SUBJECT: Administrative Approval for Petition No. 2009-039 CATS North Davidson BOD
Facility Renovations and STS Expansion

Re: Rezoning Petition #2009-039 – CATS North Davidson BOD Facility Renovations and STS Expansion

Enclosures: 4 copies of revised RZ-1 dated 6/7/13

PROJECT NUMBER: REZONING SITE PLAN
 SHEET NUMBER: RZ-1
 SHEET 1 OF 1

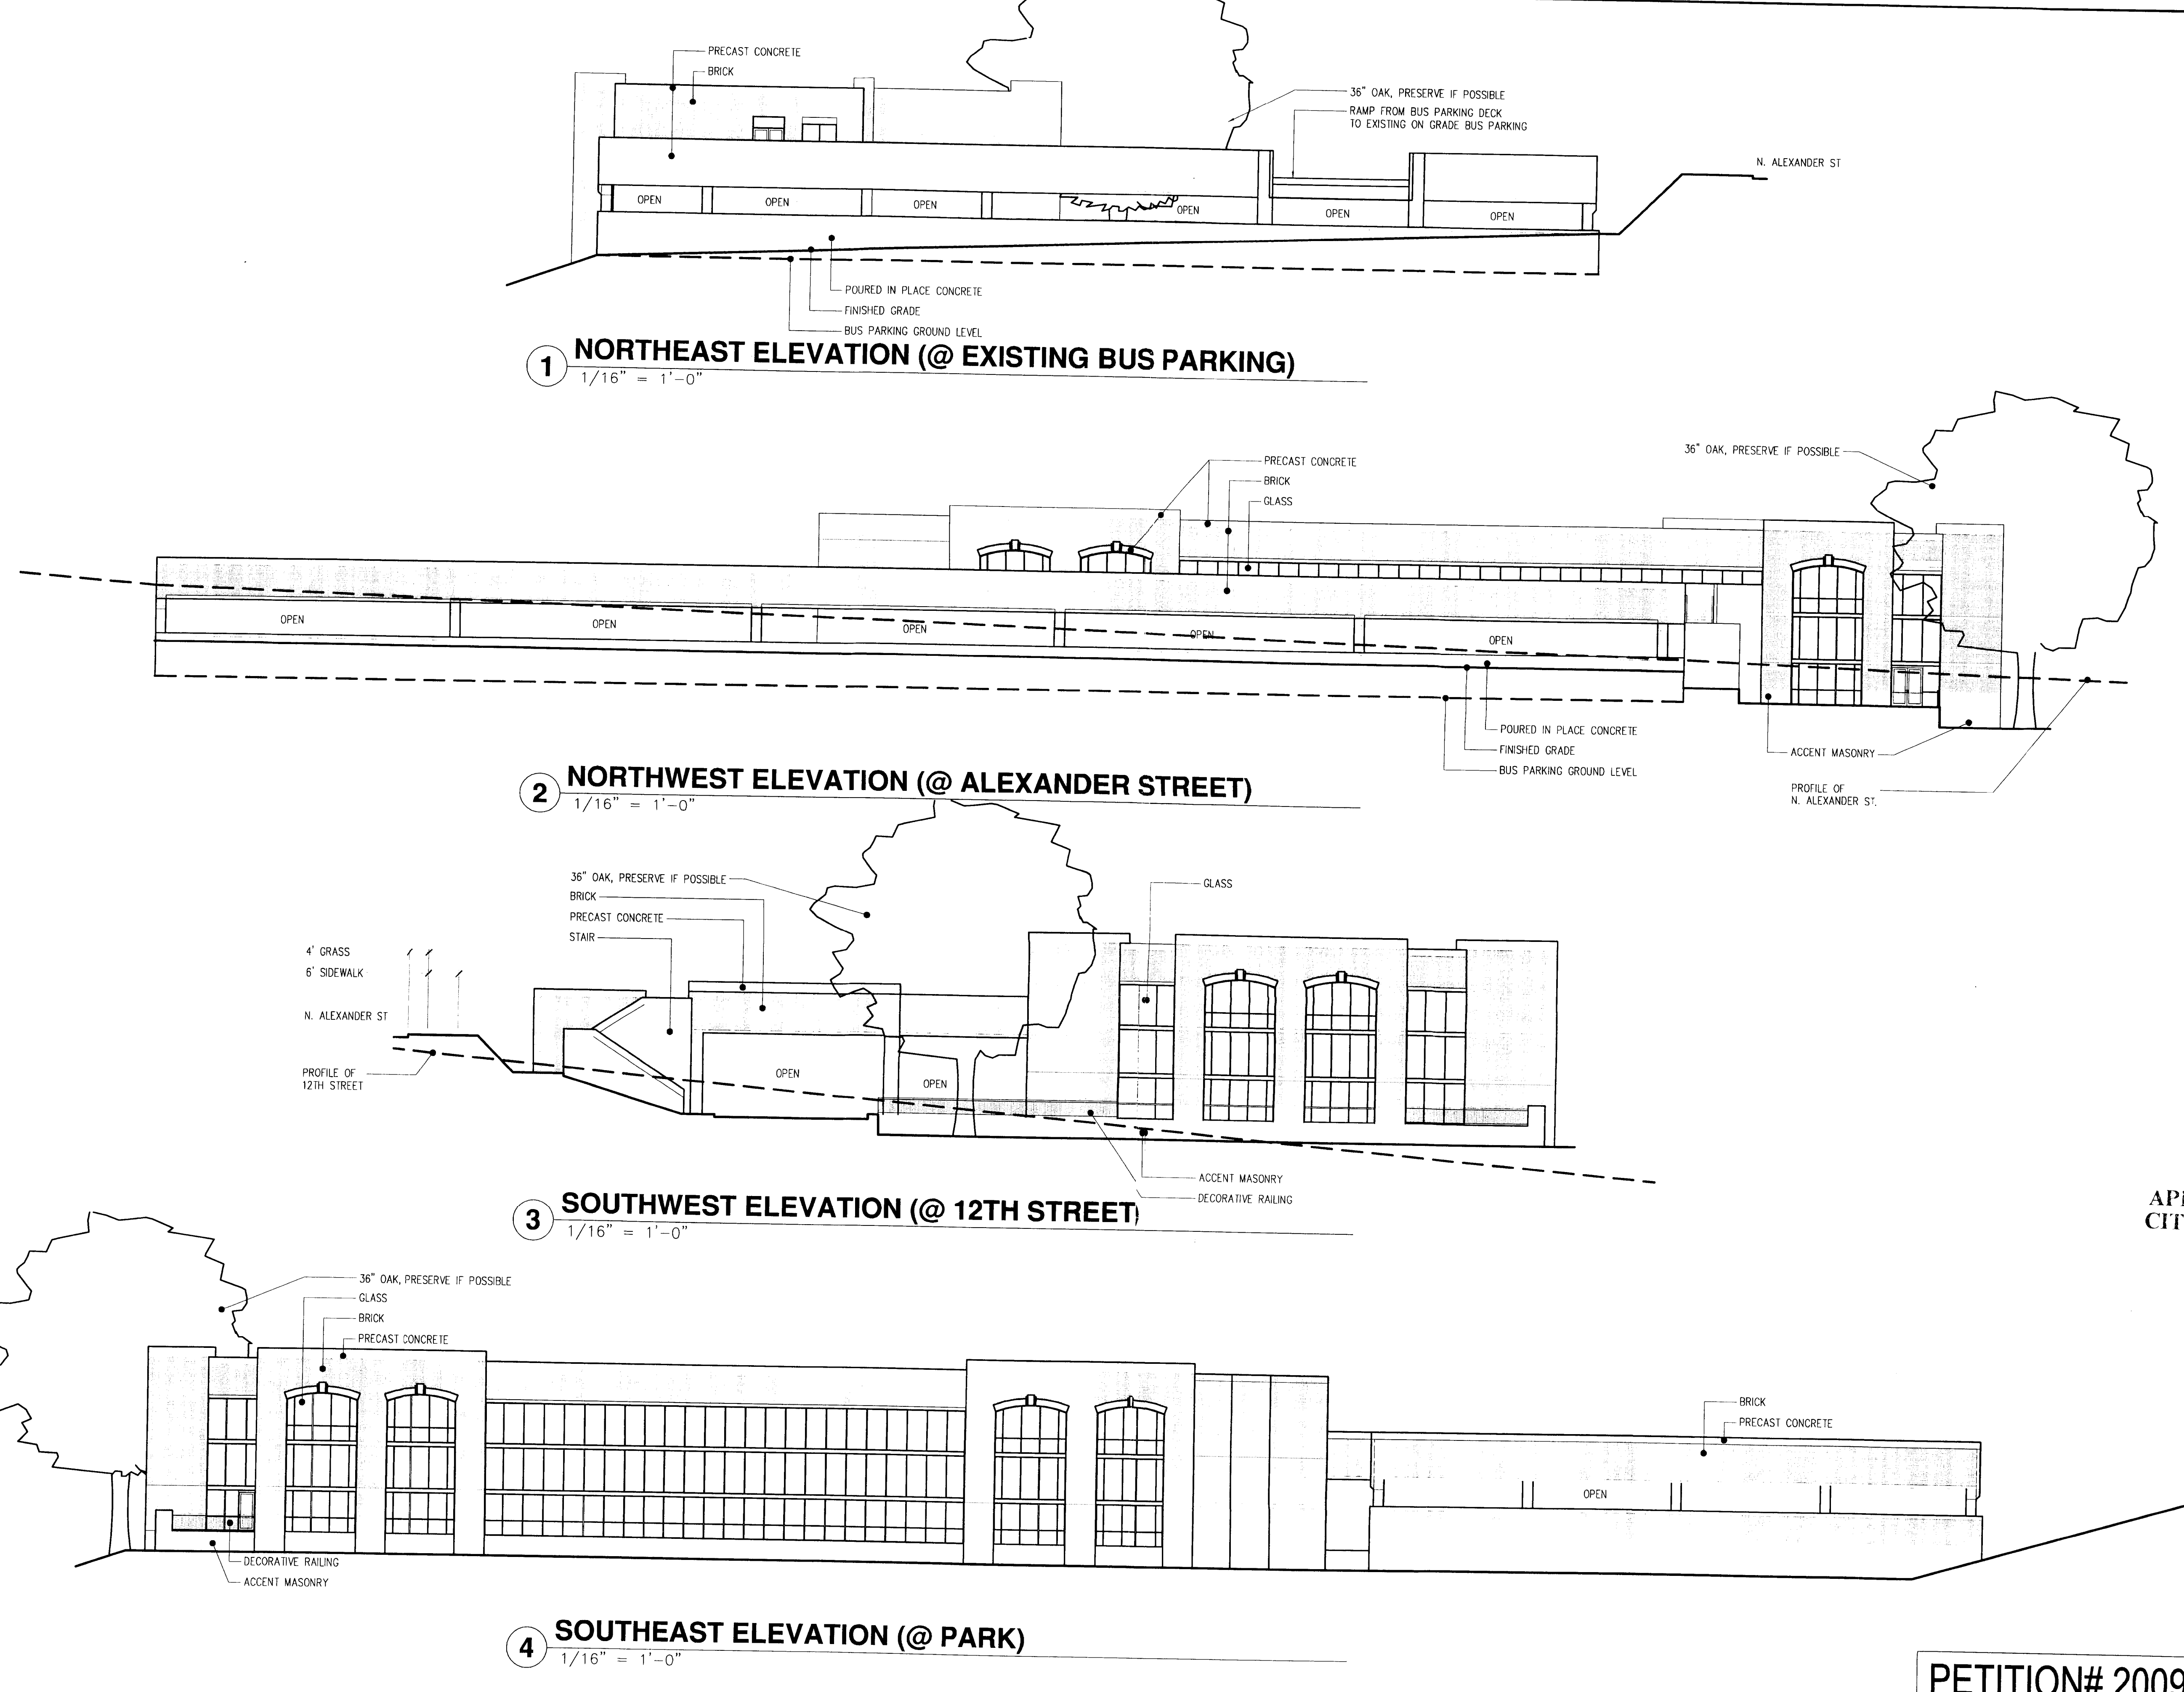
Attached is a revised site plan for the above referenced rezoning petition. The site plan attached shows change in the site layout to allow the construction of restroom facilities to server the Parks and Recreation field and park. The buffer is being adjusted as indicated to allow for the restroom facilities and is still required. All site plan notes and commitments approved as a part of rezoning petition 2009-039 apply (see attached). Since this change does not alter the intent of the development and meets the requirements of the Charlotte Zoning Ordinance Section 6.207 Alterations to Approval, minor changes, I am administratively approving this plan. Please use these plans when evaluating requests for building permits and certificates of occupancy.

The only modifications to the site plan are the addition of the restroom building and a shift in the proposed Class 'C' Buffer to the northwest. We understand this rezoning site plan change can be approved administratively. Please advise if you require any additional information.
